Arun District Council
Arun Civic Centre
Maltravers Road
Littlehampton
West Sussex BN17 5LF
Planning & Building Control General Enquiries
Tel: (01903) 737756 Fax: (01903) 730442
Dx: 57406 Littlehampton
Minicom: 01903 732765
e-mail: planning@arun.gov.uk
website: www.arun.gov.uk/planning

Application No: M/91/21/PL
Site Address: 27 Central Drive Middleton-On-Sea PO22 7TT
Description of works: Variation of condition 2-approved plans & removal of condition 4-materials included on plans imposed under M/25/19/PL.

Thank you for your internet representation made on 17th August 2021 which has been recorded as an objection with the comments as follows:

PROJECT	27 Central Drive - Elmer Beach	DATE	16/09/18
TITLE	Proposed South Elevation	DRG NO	IBA/507/05
SCALE	1 : 50	REVISIONS	B

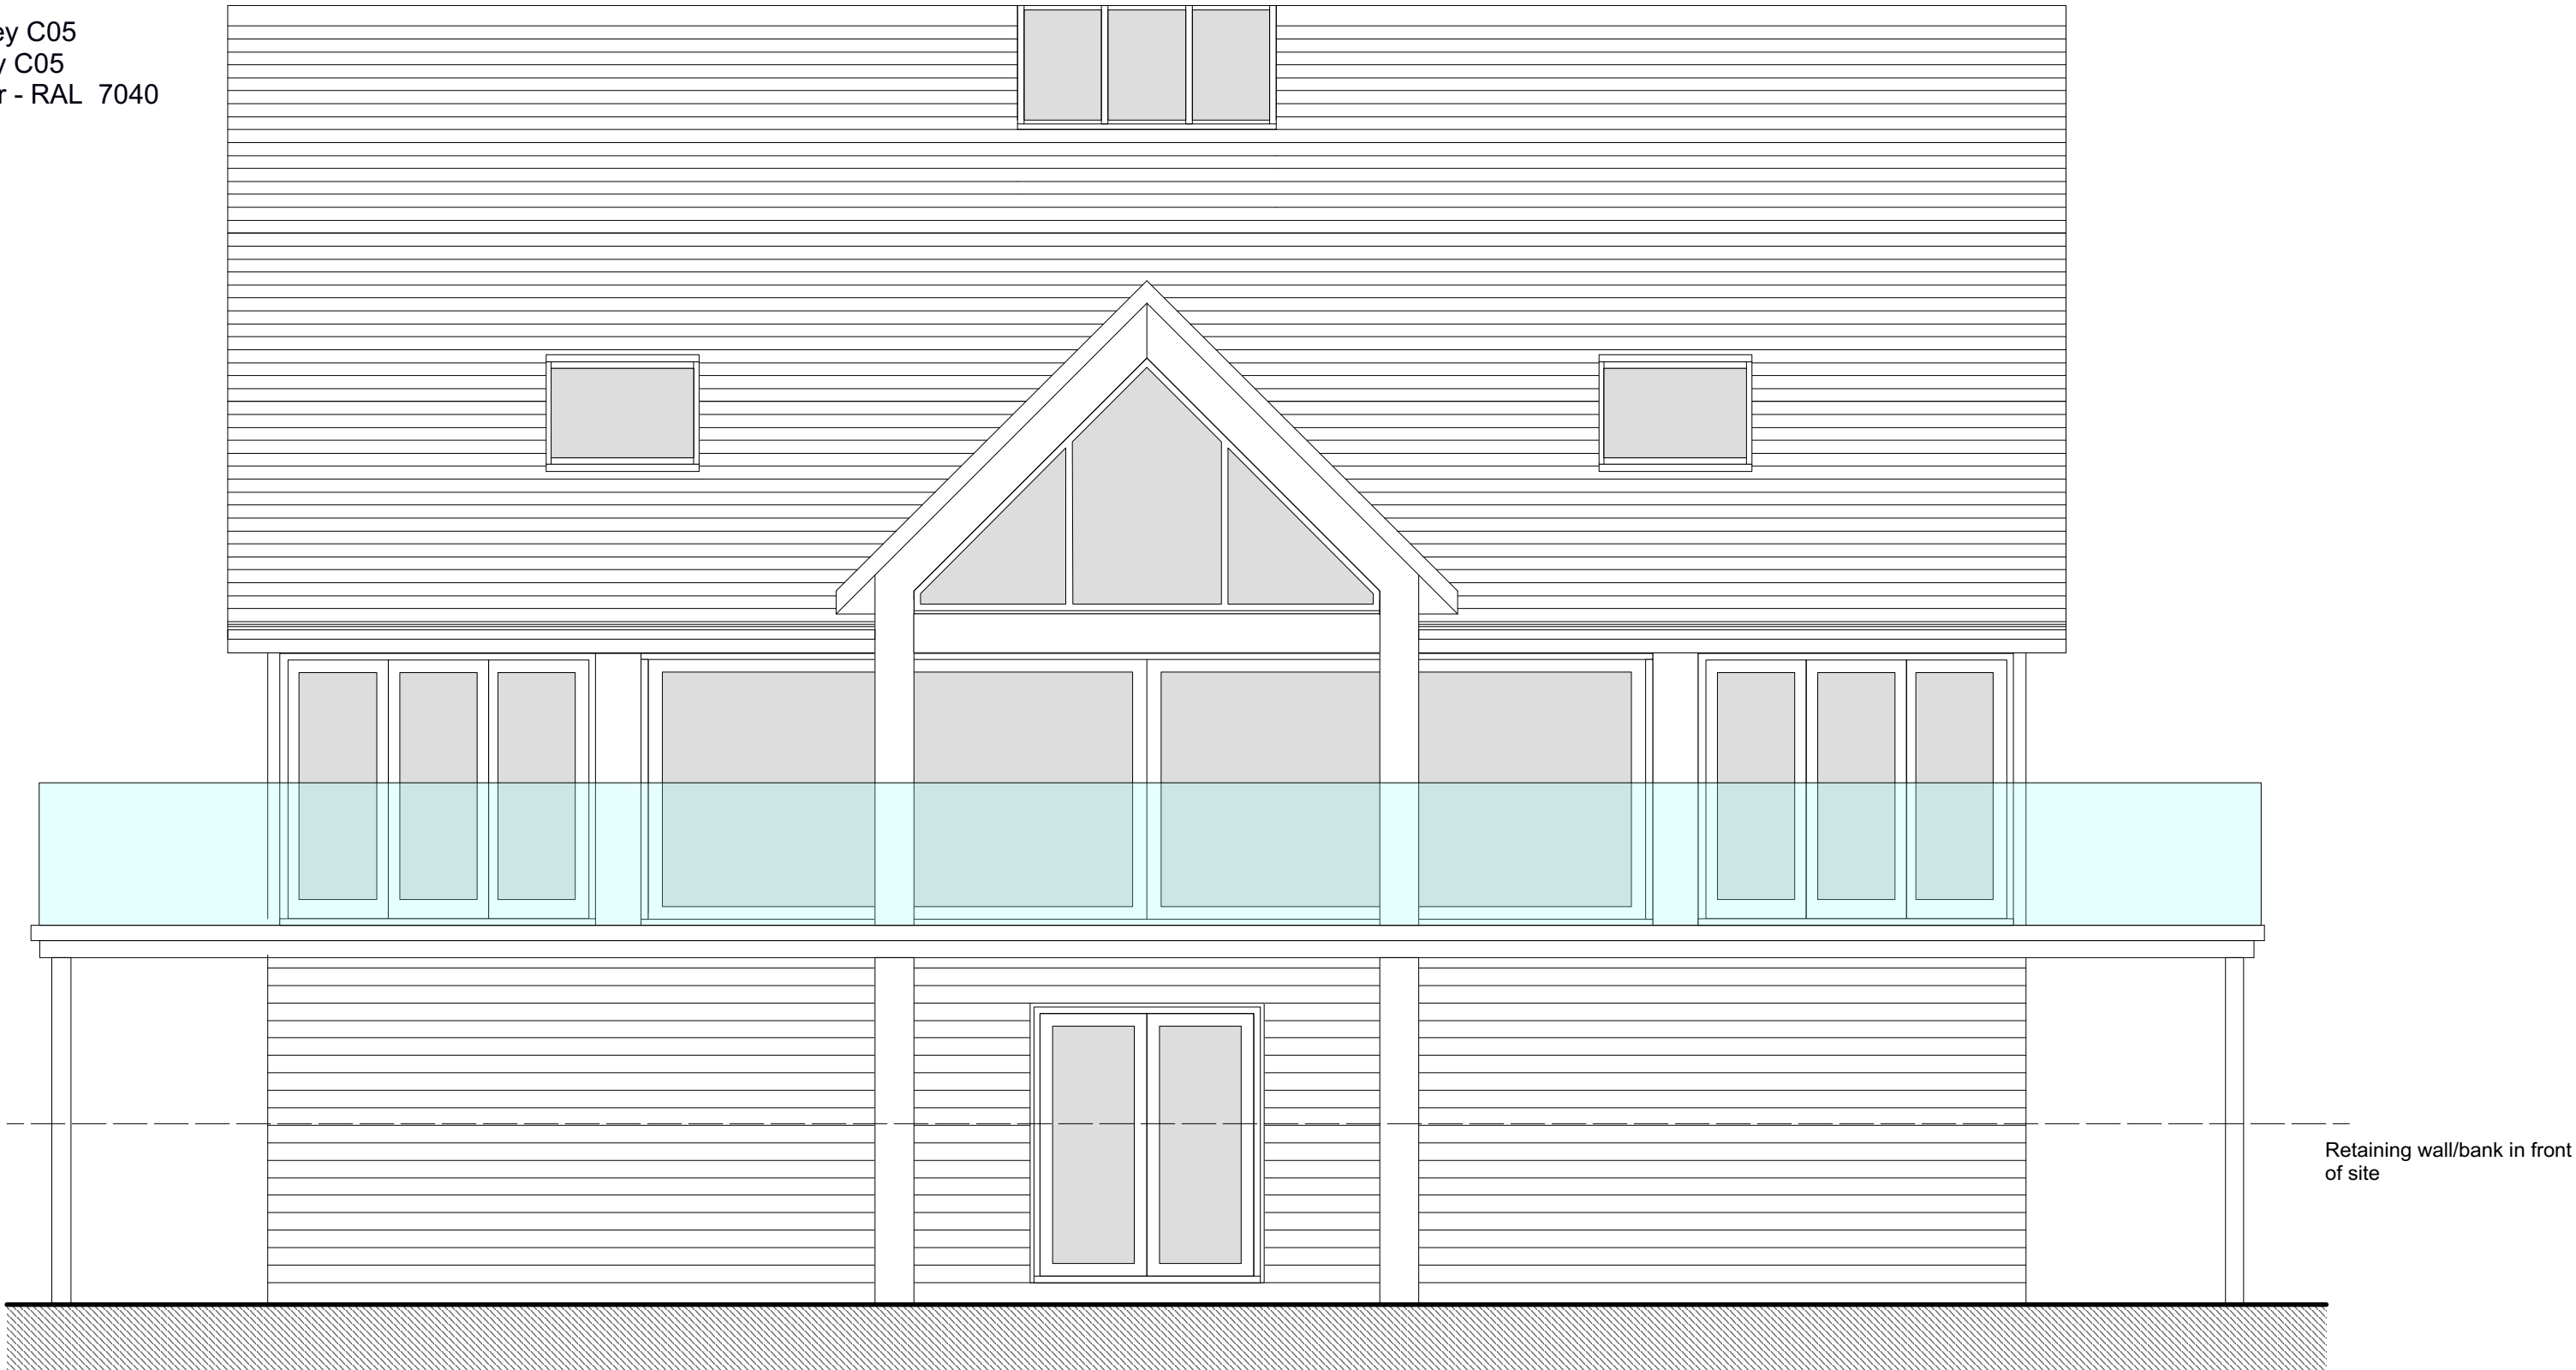
A clue perhaps to how this build is contentiously so much taller than the public saw from the conditionally approved plans (M/25/19/PL: Substitute Plan North Elevation, Substitute Plan South Elevation and Street Scene and Street Scene).

If you look at the builder's publicly accessible Facebook page (Three Sixty Build) you will see two photos of the site at an early stage of development. Expand the pictures for a full view and you will see what appear to be the tall flood defence piles on which it is built. Is it possible perhaps that the architect and builder simply built to their original plans but started from the top of the piles rather than ground level?

If so did they not understand that this would make the building considerably taller than approved (by the height of the piles) or did they just hope that members of the public, and the Arun Planning Department, would somehow, magically not notice?
